Re: Soil, Geology, and Geologic Hazard Study
Crowe Subdivision
Parcel No. 61280-00-001
15980 Roller Coaster Road
El Paso County, Colorado

Mike and Ruth Crowe
Soils, Geology, and Geologic Hazard Study
Crowe Subdivision
Parcel No. 61280-00-001
15980 Roller Coaster Road
El Paso County, Colorado

# CROWE SUBDIVISION FILING NO. 1 - SITE PLAN

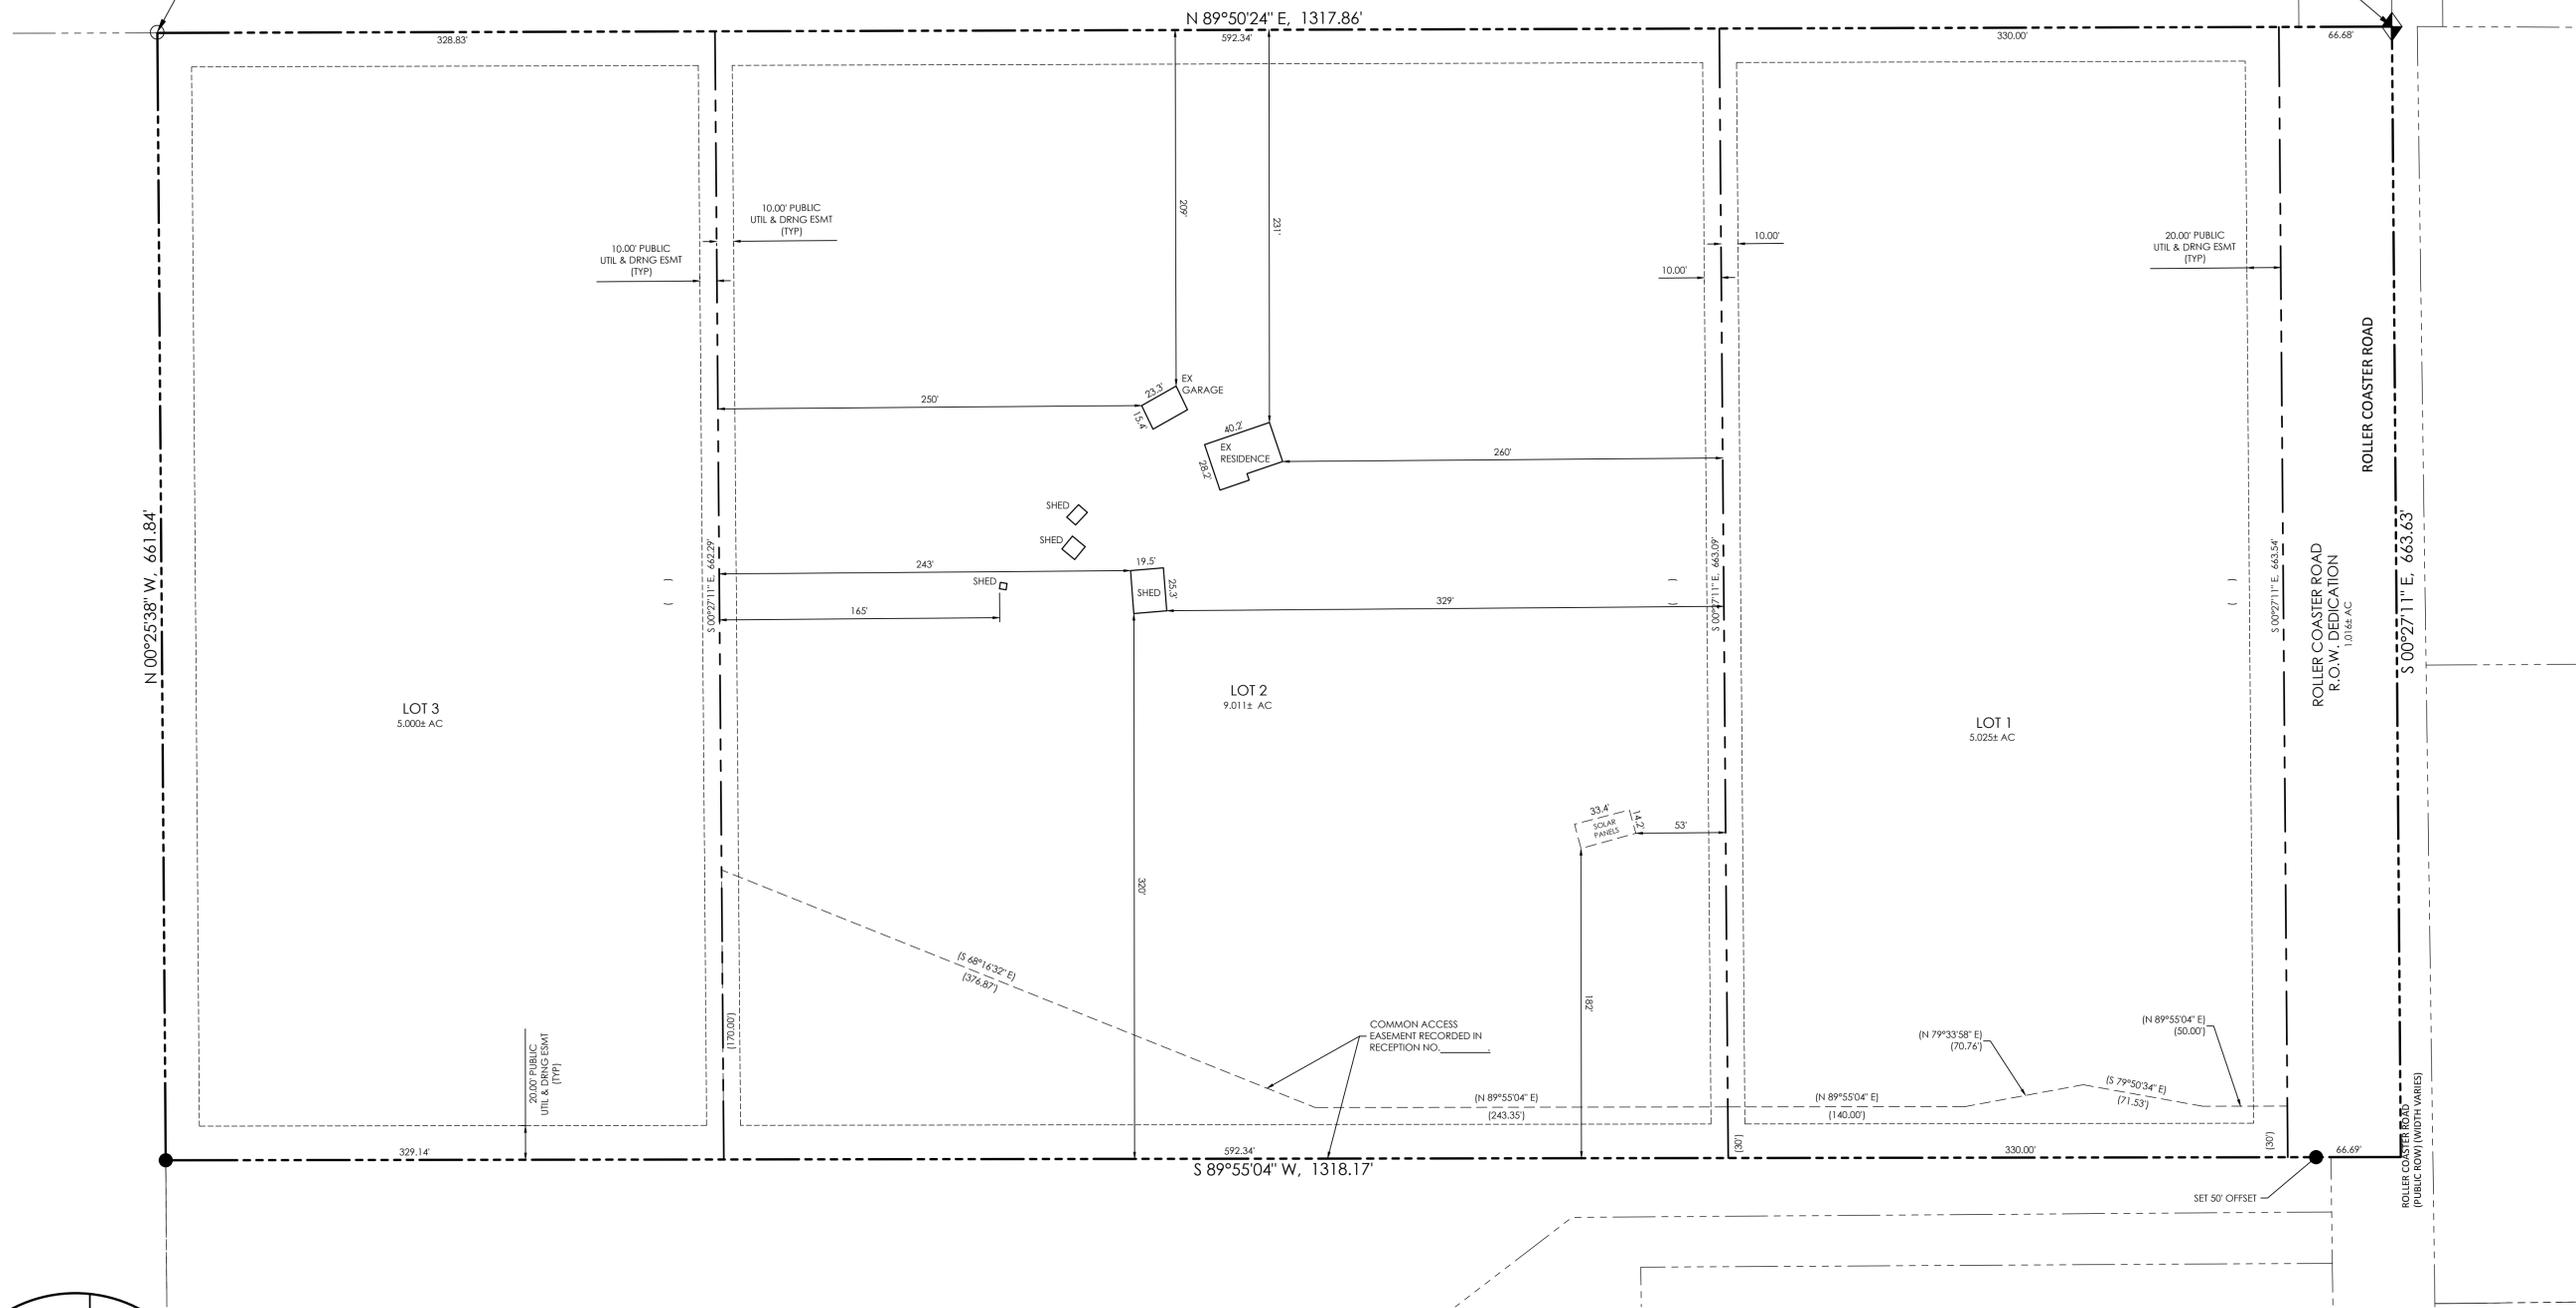
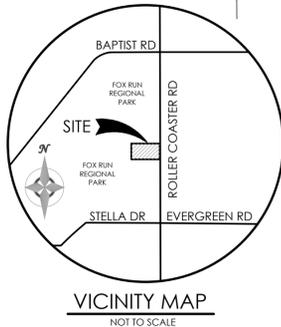
please identify as
 no-build area on plat

show hazard areas as
no build on plat
note.update report to
show hazard areas

add a plat note
regarding mitigation
